Consultation Response from KC, Highways Development Management
2026/91505 Fleece Farm, 15, Midway, South Crosland, Huddersfield, HD4 7DA
Prior notification for change of use of agricultural building to 6 dwellings and associated works
Date Responded: 14/07/2026
Responding Officer: CNB
Responding Ref: K3-24/7
This is a prior notification application for the change of use of 2 agricultural buildings to 6 dwellings within a farmyard with an existing access off Midway, a 30mph two-way single carriageway rural distributor road of approximately 7m width with a footway on the side of the application site and street lighting present. The site is approximately 120m from stops on a low frequency bus route and approximately 520m from stops on a high frequency bus route. The site is approximately 1km from the closest convenience store and other retail and services. The DfT Connectivity Tool gives a score of 51 and a driving score of 82 which is regarded as very high for driving and so we would expect most trips to be made by private car. We would not expect a development of this size to generate sufficient trips as to have a severe impact on the operation or efficiency of the local highway net

BLOCK PLAN
1:500

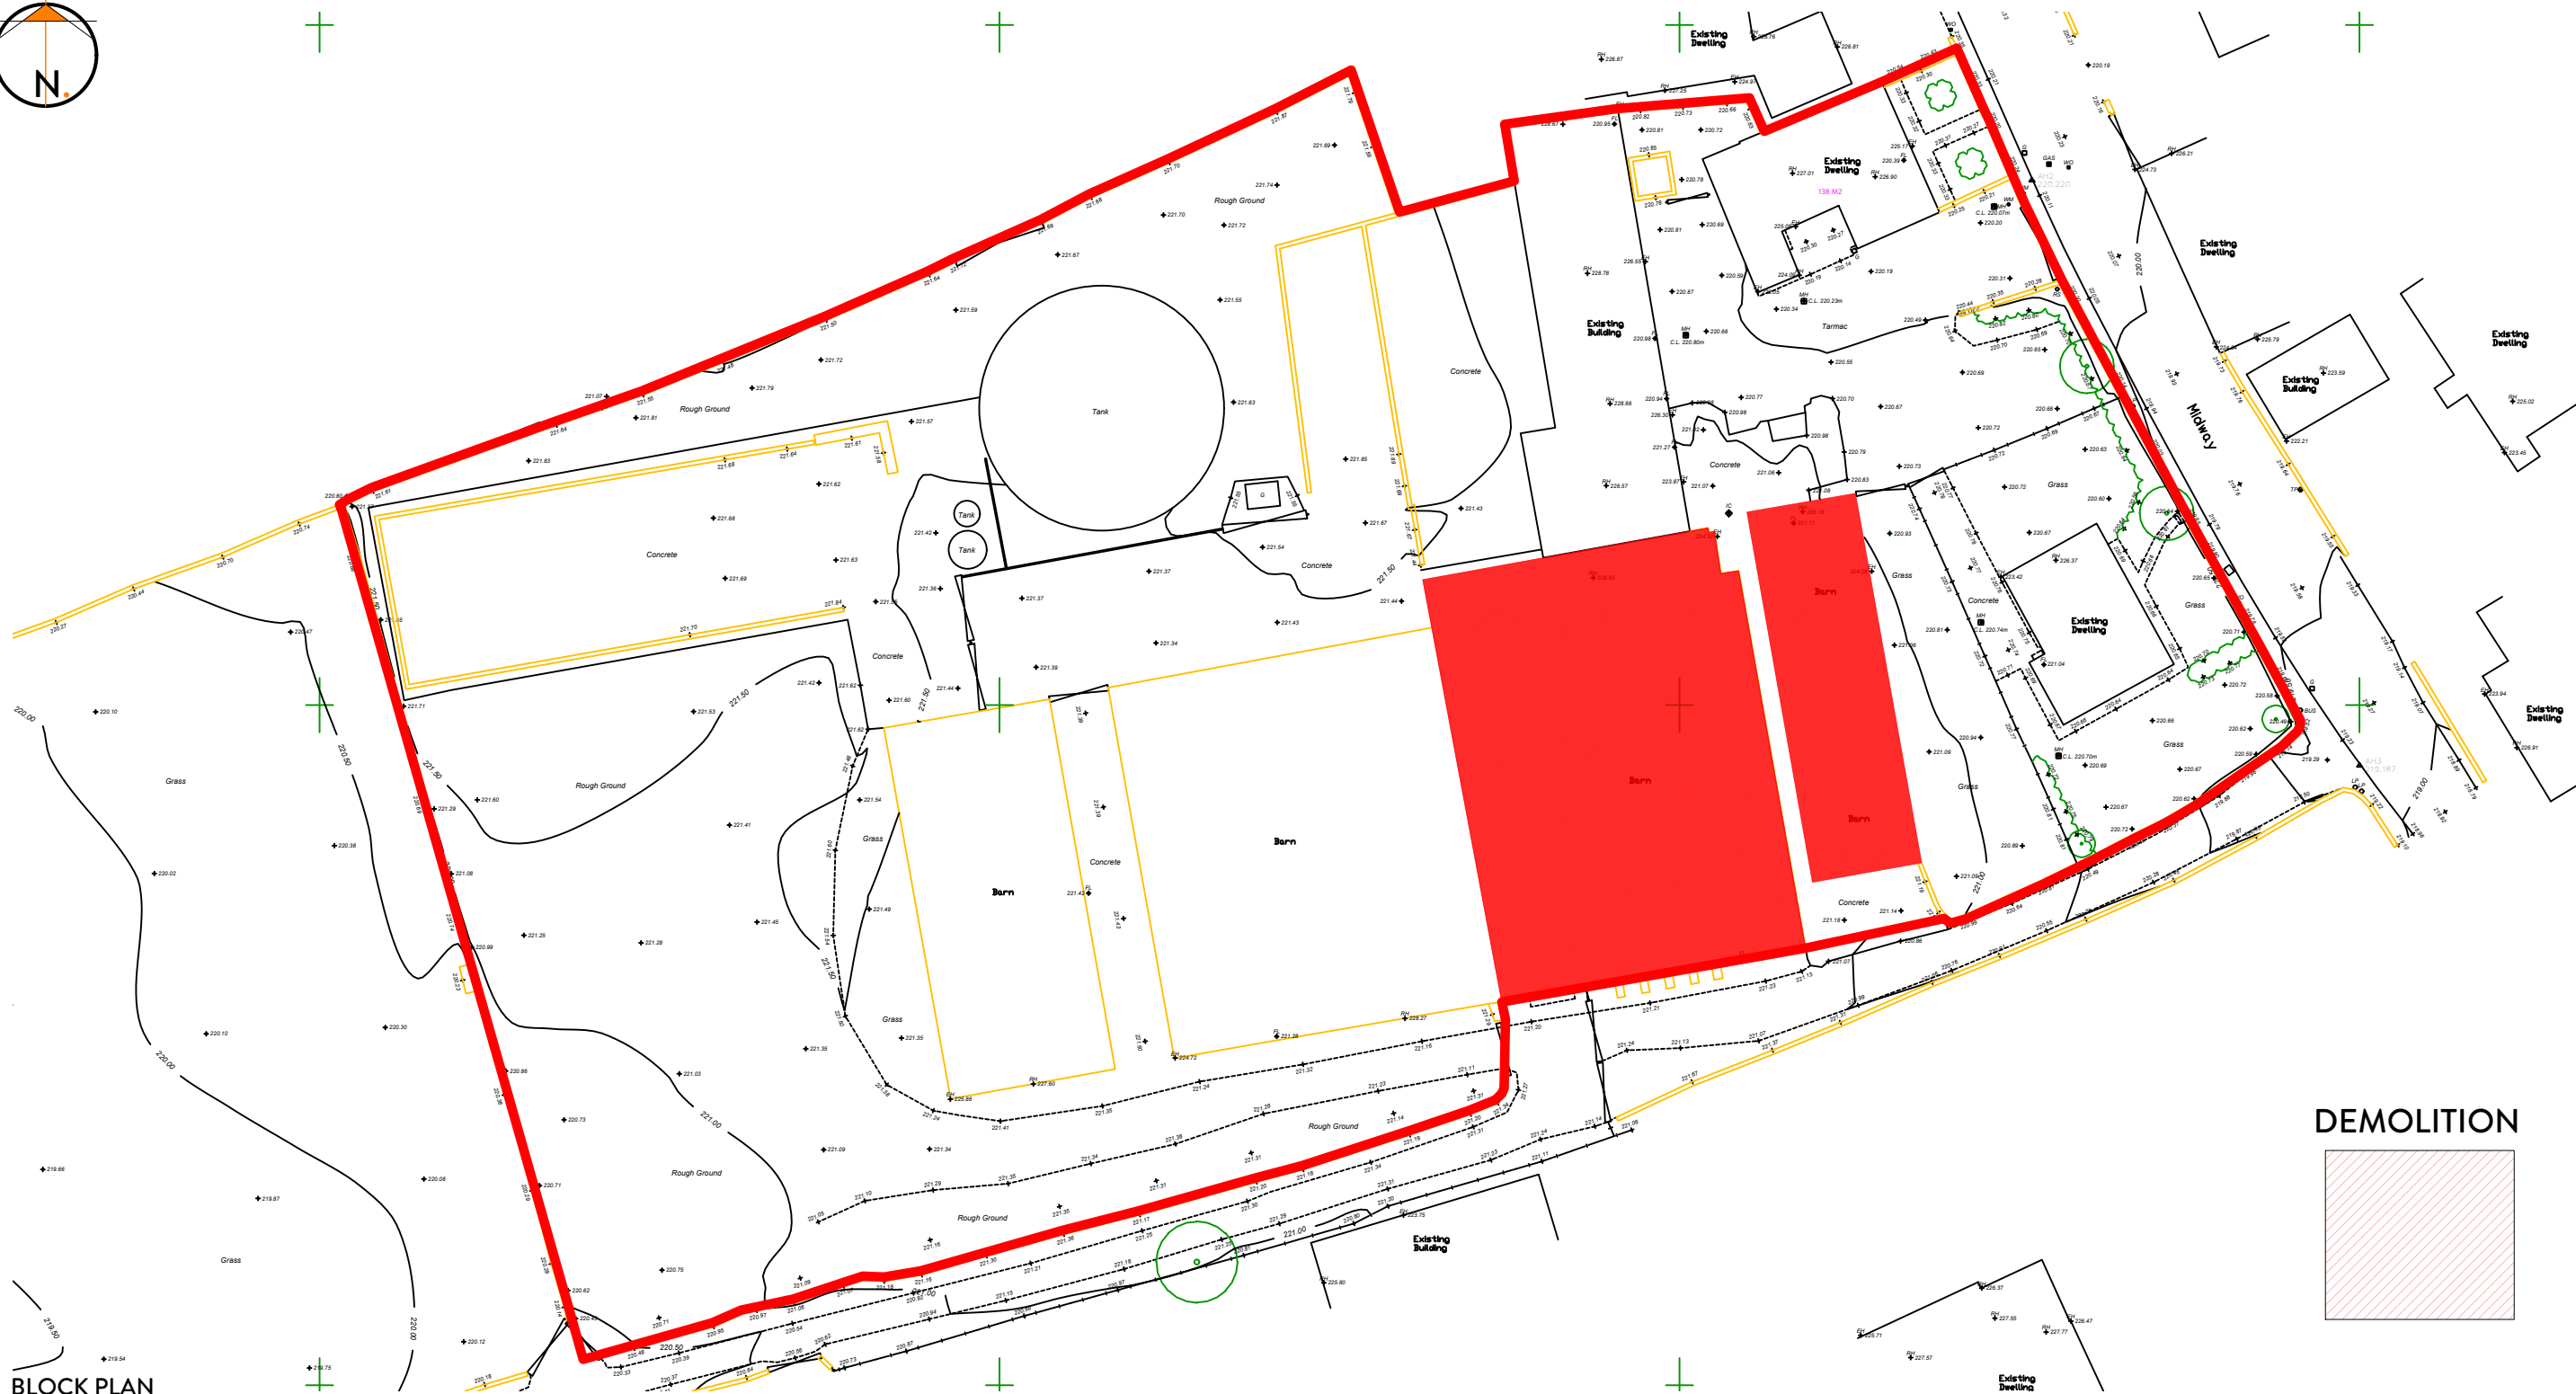
approximately 6m wide and this would be acceptable for two cars to pass. It is noted that the access is gated and we would like to see either the gates removed or set back 5m from the rear of the highway to allow a car to pull clear of the highway while waiting for the gates to be opened and this should be conditioned.

No visibility splays have been submitted for the access, as we would expect an intensification of use of the access with the development, we would like to see visibility splays of 2.4m x 43m clearly displayed on a drawing. These should be to the nearside kerb and cross nothing greater than 1m in height. If these full visibility splays cannot be achieved then we would be happy to see a reduction in the Y-length of the splay based on observed 85th percentile speed data obtained from an ATC on Midway and constructed to Manual for Streets calculations. This should be conditioned for highway safety reasons. This information was requested in the previous refusal and so again we are disappointed that the applicant has decided not to obtain this information prior to the current application. Without this information we cannot assess the safety of the proposed access.

The proposals are for 6 two-bedroom dwellings and to follow local guidance this would require 2 off-street parking spaces per dwelling with one visitor parking space per 4 dwellings. Drawing No (20) 003 Proposed Block Layout shows that 12 resident spaces and two visitor spaces can be provided with suitable turning and manoeuvring space and this is acceptable.

Prior to the development being brought into use, the sightlines of 2.4m x 43m along Midway shall be shown on a plan and presented to the local planning authority for written approval and afterward these visibility splays be cleared of all obstructions to visibility exceeding 1m in height and these shall be retained free of any such obstruction throughout the lifetime of the development.

Notwithstanding the provisions of the Town and Country Planning (General Permitted Development) Order 1995, (or any order revoking and re-enacting that order) any gates or barriers for or over a vehicular access or egress shall be set back 5m from the back of the footway on Midway and shall be hung as to only open inwards. So long as such gates or barriers are in position they shall be retained to only open inwards.
